Project Name	Cottages at Mesa Ridge Subdivision
File Prefix	SF - Final Plat
Year	2022
Applicant	HR Green pstuepfert@hrgreen.com (pstuepfert@hrgreen.com)
Owner	Goodwin Knight and CSJ NO 1 LLC same 8605 Explorer Drive, Suite 250 Colorado Springs, CO 80920 dmorrison@GoodwinKnight.com
Description	(719) 598-5192 Final Plat to legalize existing parcel to create a single lot with multiple tracts for private roads for public access, detention, park land
Location	
Parcels	5529100006
Comment	PUD in concurrent review for manufactured home cottage rental community
Project Area	12.93 acres
Zone	RS-6000
EA Number	EA2054
File Number	SF2214
Project Manager	Kari Parsons (kariparsons@elpasoco.com) (719) 520-6306

Request for Comments

Agency	Fountain Mutual Irrigation Company
Comment	Please review all required documents, and add any review comments
Due Date	5/3/2022

FINAL PLAT
COTTAGES AT MESA RIDGE

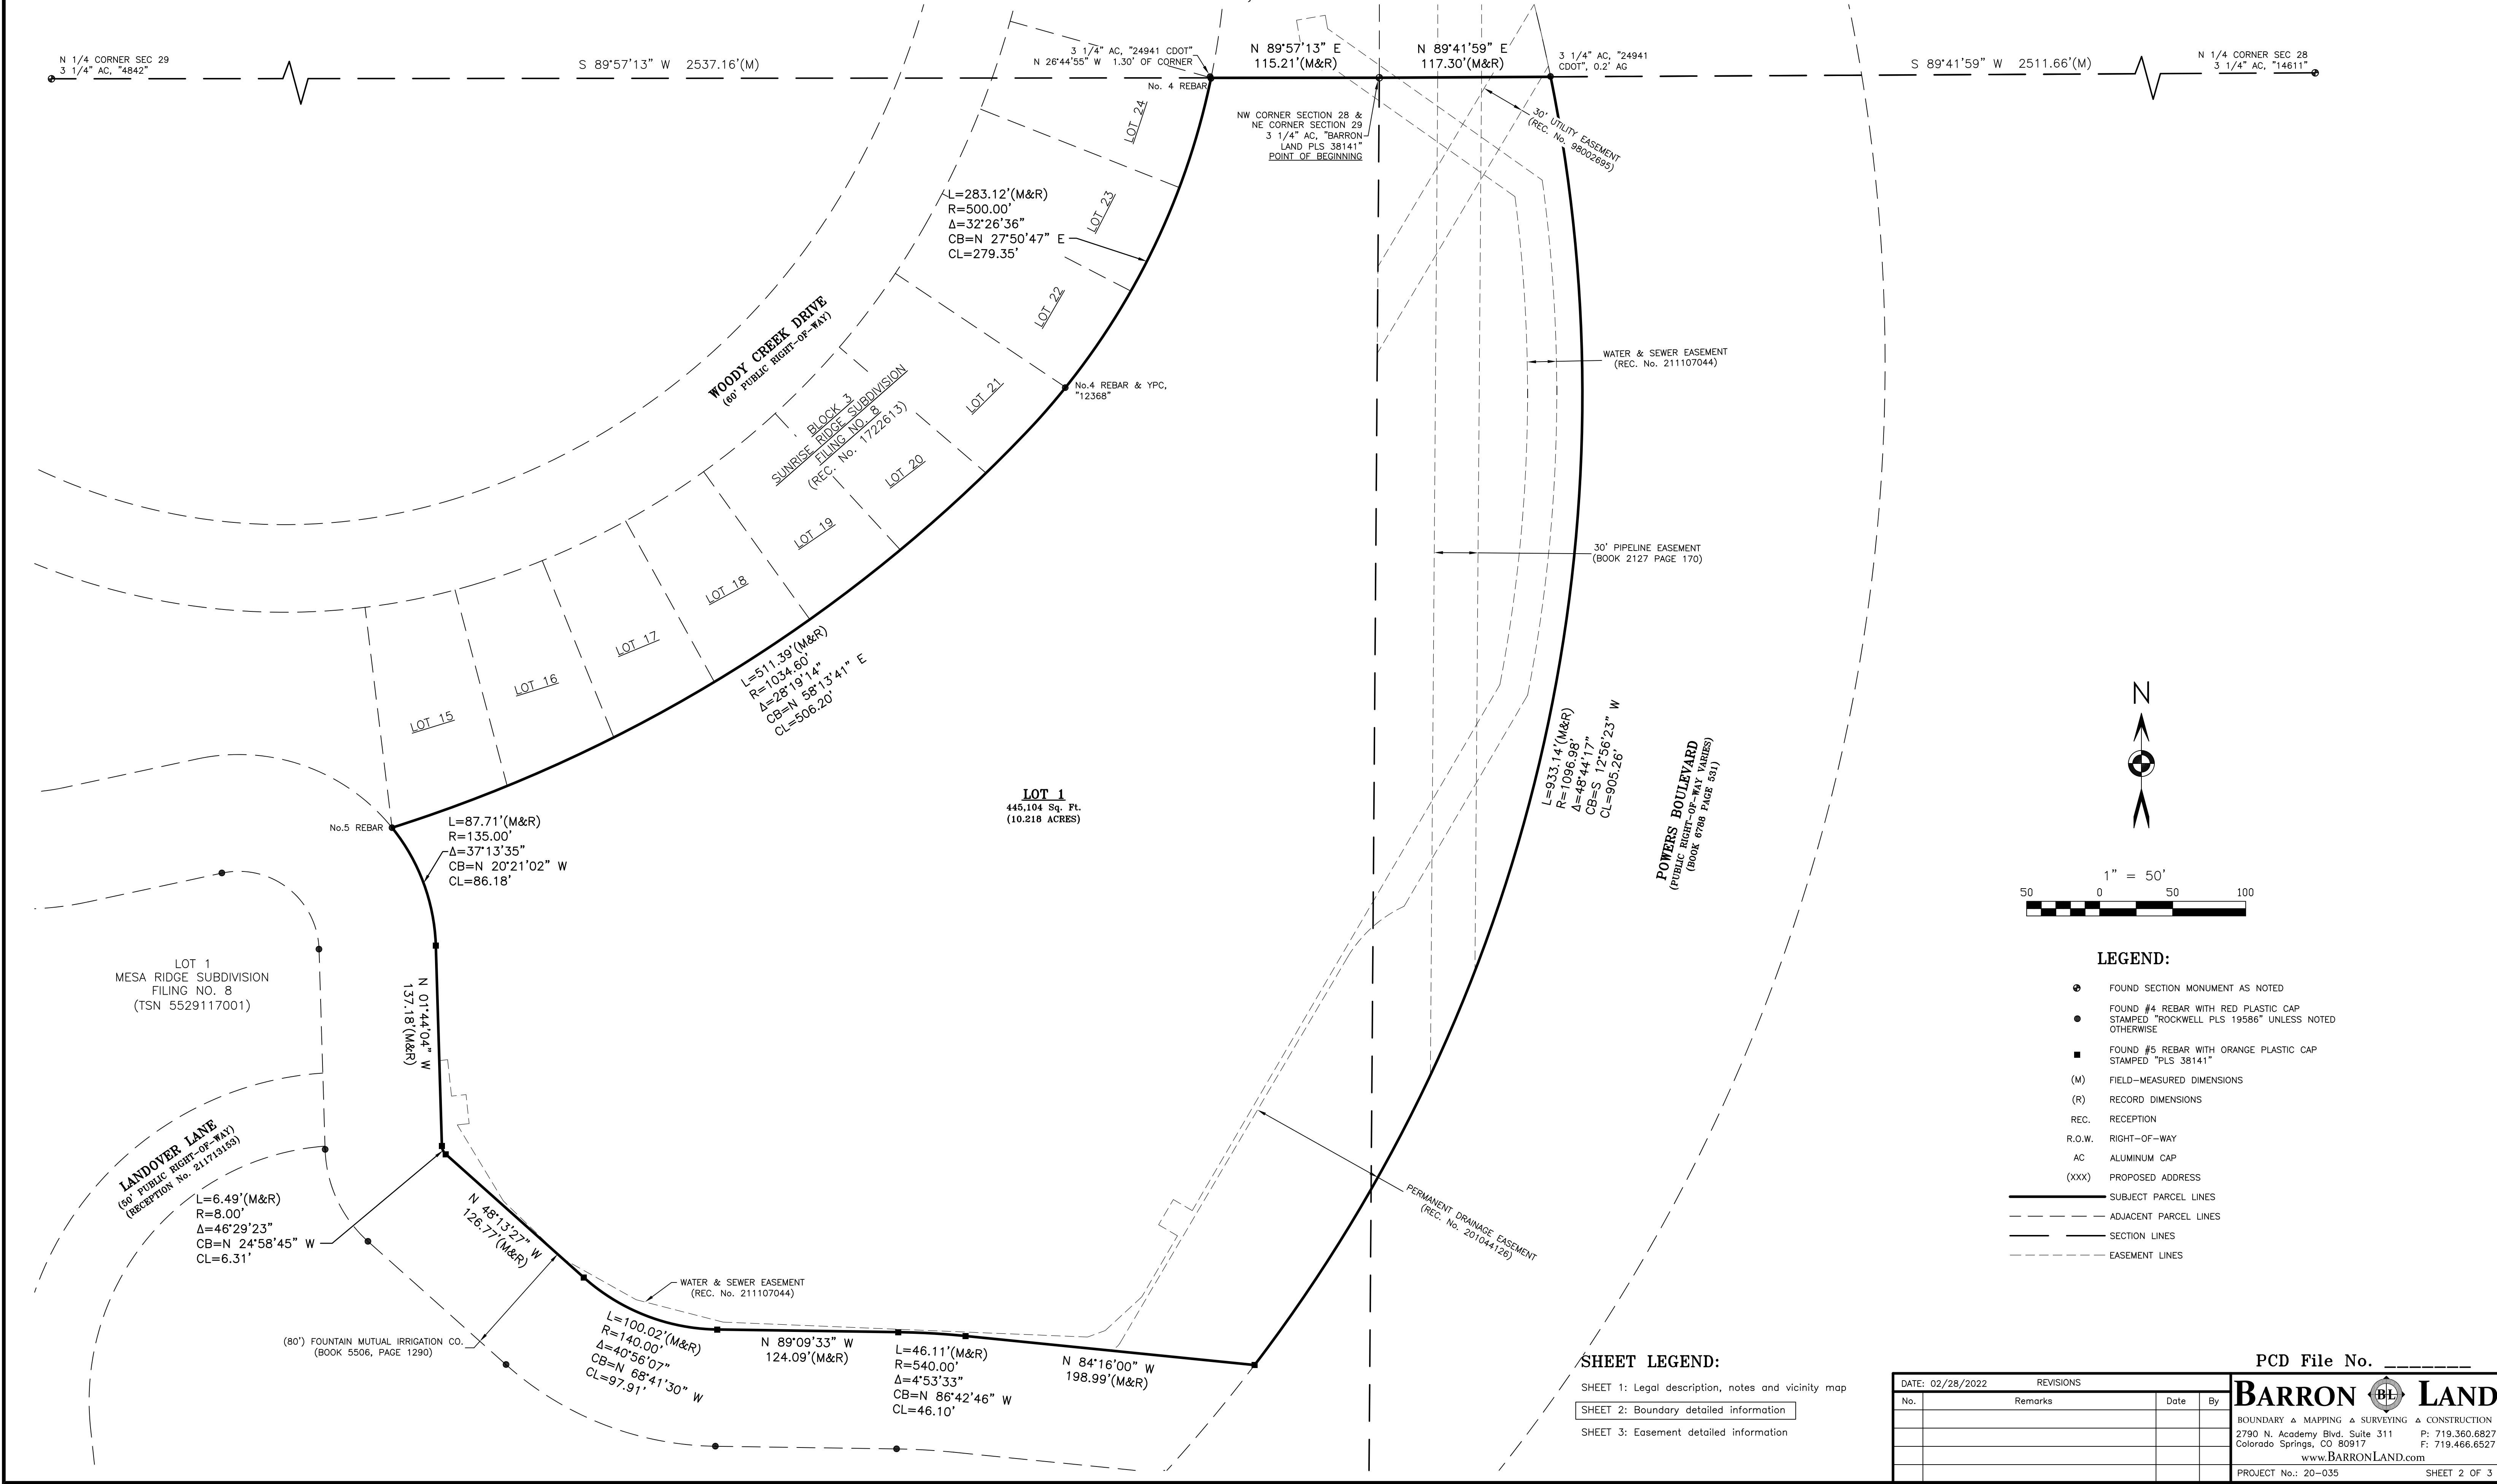
FMIC provided comments for the initial submittal of this project back on 9/16/21 and have a few additional comments relating to additional design plans and final plat affecting the canal system. The final plat depicts the FMIC canal located within both a deeded 80' right-of-way (ROW) and recorded easement. This project will extend the existing 66" diameter RCP pipe located within the 80' ROW into the existing easement and tie into the existing concrete lined canal prior to crossing beneath the existing concrete culvert at Powers Blvd. FMIC has no issues with the proposed design plans for this proposed extension of the 66" diameter pipe except for the proposed landscape plans that are depicting a couple of large trees to be installed within the existing FMIC easement close to this proposed 66" diameter pipe. Please remove these two trees from the landscape plan due to future maintenance activities within this easement area. In addition, please add locking rings and covers to the proposed manholes to prevent any vandalize or unlawful entry into these manholes as well bring all manholes to finish grade once project is complete.

In addition, a portion of the FMIC ROW is to be utilized for emergency fire/secondary access for this project. This access roadway will be maintained by the Metro District/HOA for the development project and not available for general public access. The extension of Landover Lane will be permitted across the FMIC ROW into this proposed development project as well as the extension of public utilities across this ROW to serve this project. FMIC takes no further exception to this project at this time.

Noted in Draft Agreement
